Application No: FG/184/21/PL
Site Address: 1 Greenways Crescent Ferring BN12 5EF
Description of works: Erection of replacement dwelling and garage

Thank you for your internet representation made on 15th November 2021 which has been recorded as an objection with the comments as follows:

Figure 3: Existing and proposed west elevations

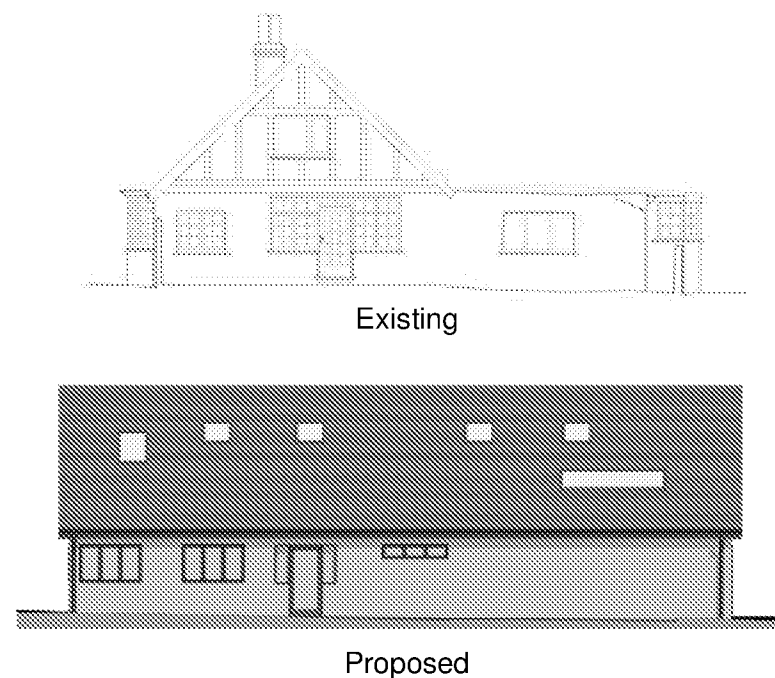
(c) It seems to me that the west-facing ground floor windows of the room described as "the snug" will protrude beyond the end of the current boundary fence running between Number 1 and Number 2 Greenways Crescent. If so, extending that fence forward to maintain the current degree of privacy for the residents at Numbers 2, 3, 4 and 5, may breach planning regulations and trespass on the aforementioned grass verge.

Figure 4: Existing and proposed north elevations

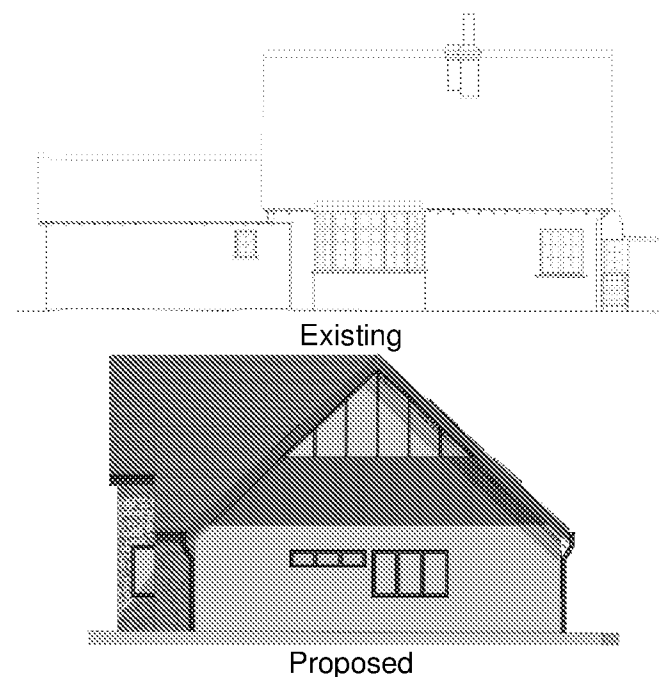
(1) The proposed northern elevation of the new property will be closer to the road than the existing house and I suggest this is undesirable because:-

(a) Greenways Crescent has grass verges instead of pavements. If I am interpreting the deeds of my own property correctly, all the residents of the Crescent, which is a private road owned by Crown Estates, have a pedestrian right of way over the grass verges, (in lieu of a pavement), including over the verge at Number 1 Greenways Crescent. If so, the north facing elevation of the new house would be extremely close to that pedestrian verge.

(b) The prominent position of the northern elevation of the new house would be inconsistent with the position of the established properties at Numbers 2, 3, 4, 5, 6, 7, 8, 9 and 10 Greenways Crescent which are all set well back from the road.

(3) In my view, the huge glass windows on the northern elevation of the new house will be intrusive.
